Your ref: 06_0139 MOD 6 & 7
File no: MC-06-1449

18 October 2018

Proposed modifications to Major Project 06_0139 for the Genesis Xero Waste Facility at Eastern Creek

Project	DIAL A DUMP INDUSTRIES EASTERN CREEK
Title	MOD 7 PROPOSED WEIGH BRIDGE

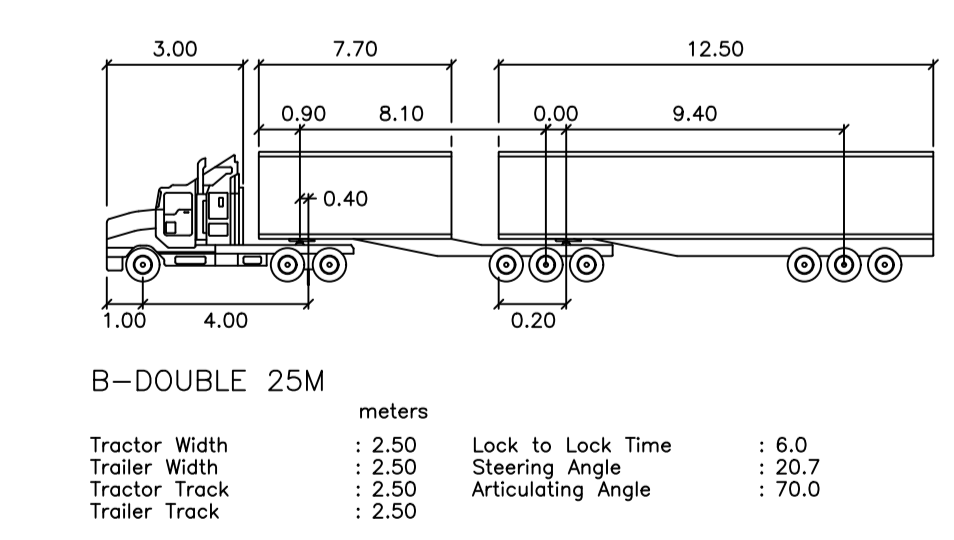
1. We require confirmation that the amended access arrangements and travel routes are considered in a current noise impact assessment.
2. We require confirmation that the management of the weighbridge operations minimise the risk of queuing on surrounding roads.

Project	DIAL A DUMP INDUSTRIES EASTERN CREEK
Title	MOD 7 SITE SECTIONS SHEET 1 OF 2

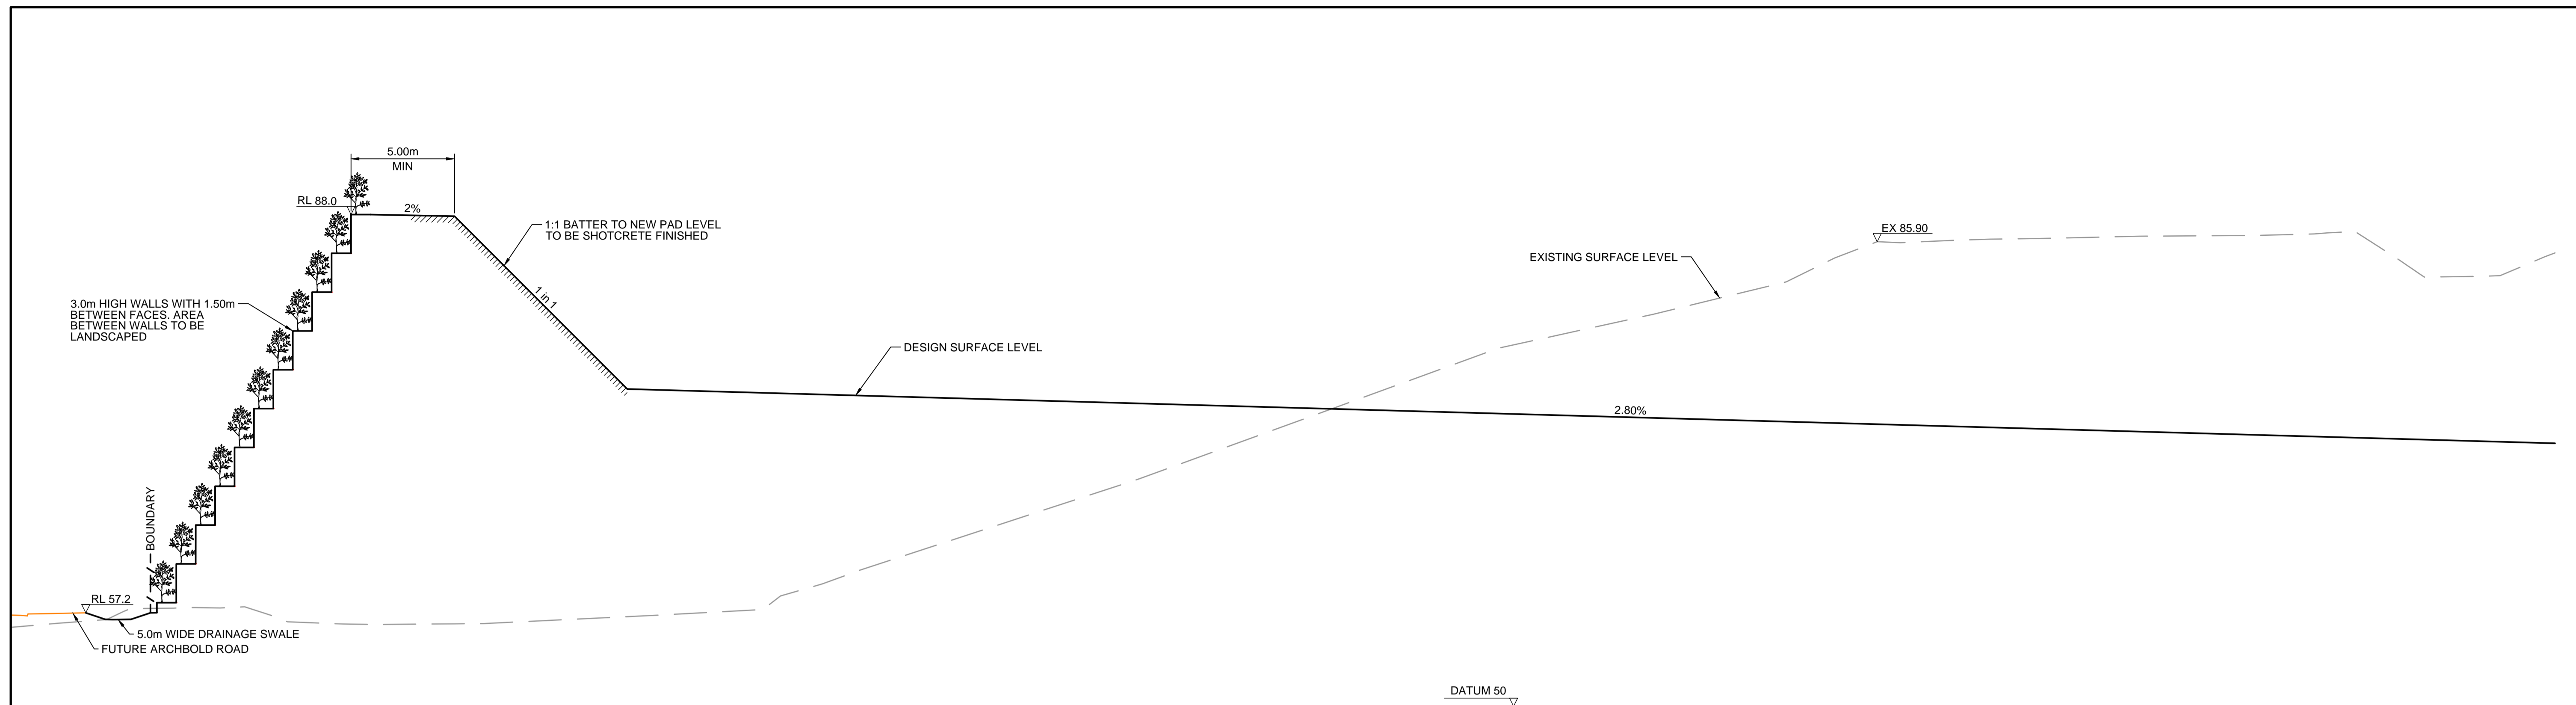
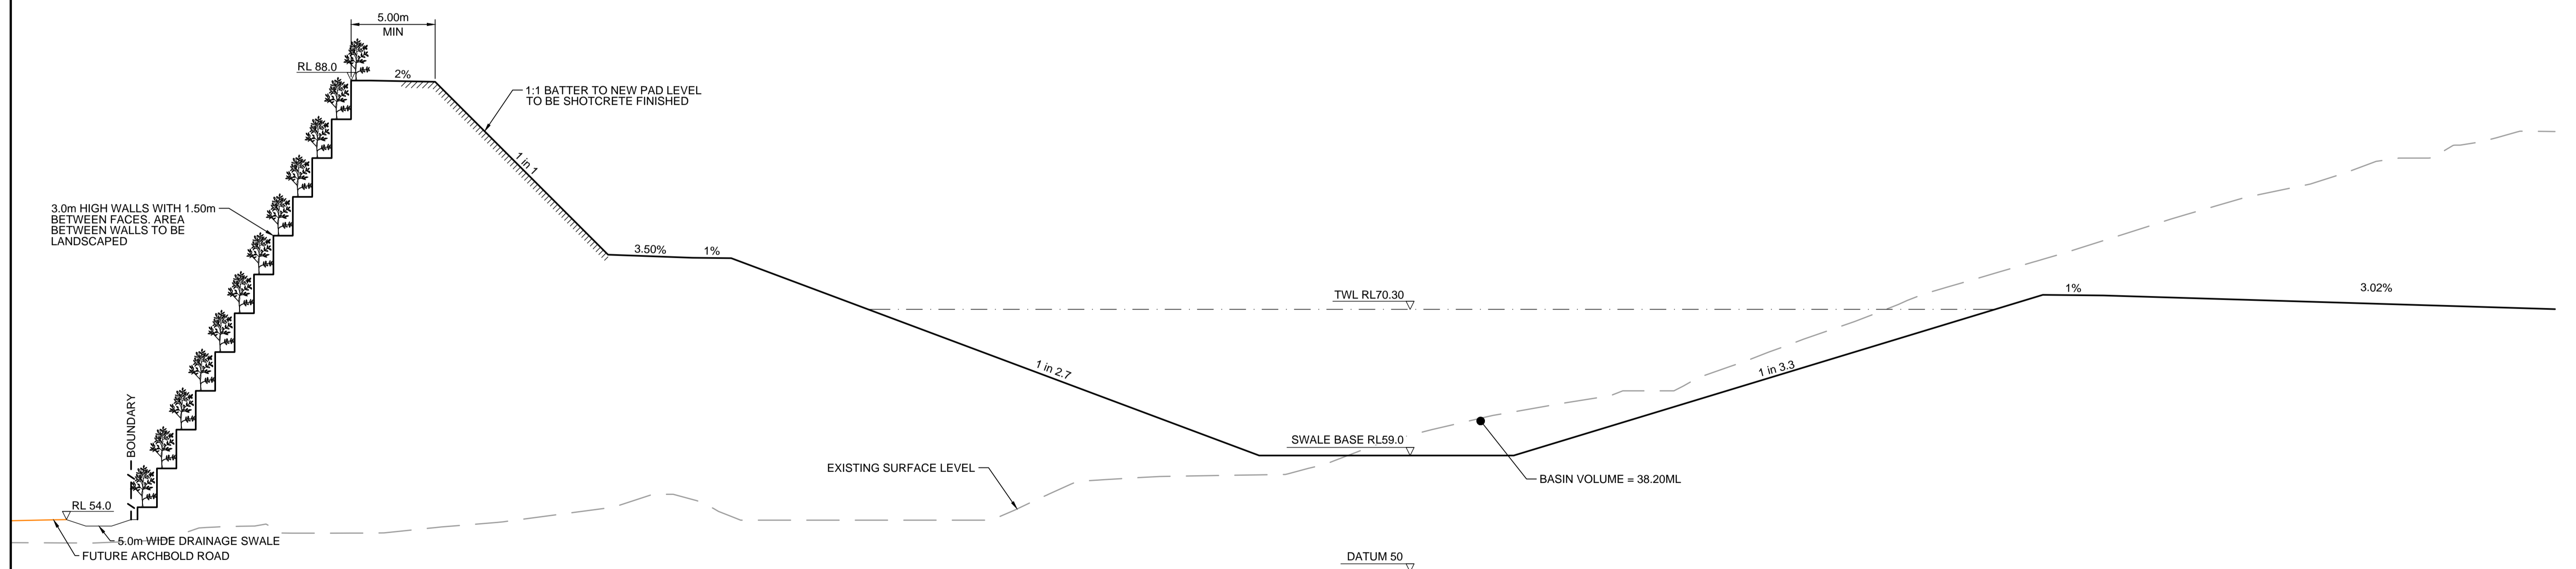
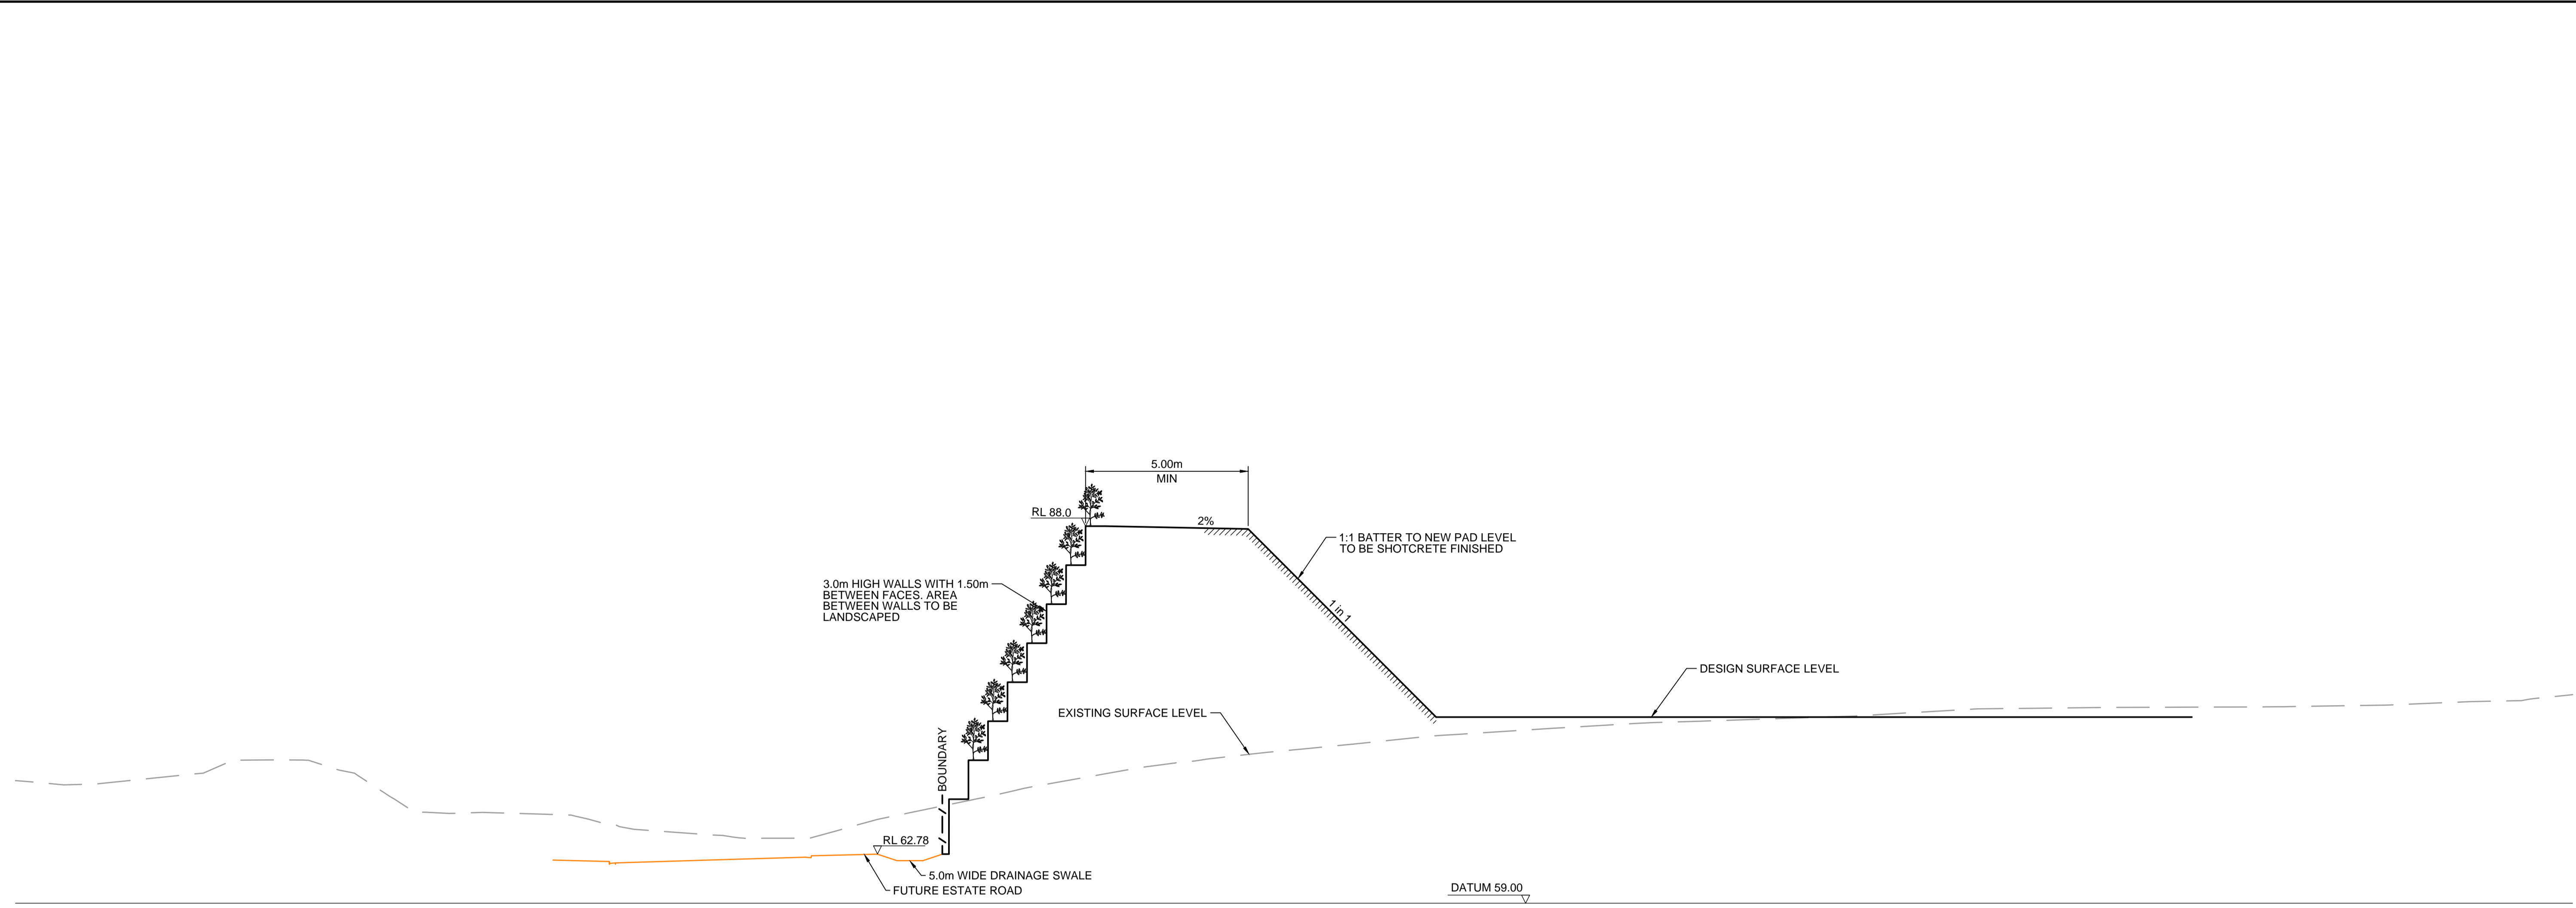
6. It must be demonstrated that the significant height of the western retaining wall structure is necessary and is the best outcome for the site and surrounds. Retaining structures are generally limited to a height of 3 m to 7 m with extensive design measures to mitigate the visual impact. Therefore the proposed retaining wall is not supported in its current form.

7. The design of the western retaining wall structure must be reviewed to improve visual amenity and align with the intent of the 'Eyes on Blacktown Strategy', taking into consideration view lines, security, planting and maintenance. This must also be considered with regard to the design of the public domain and retaining structures of the overall area and Precinct.
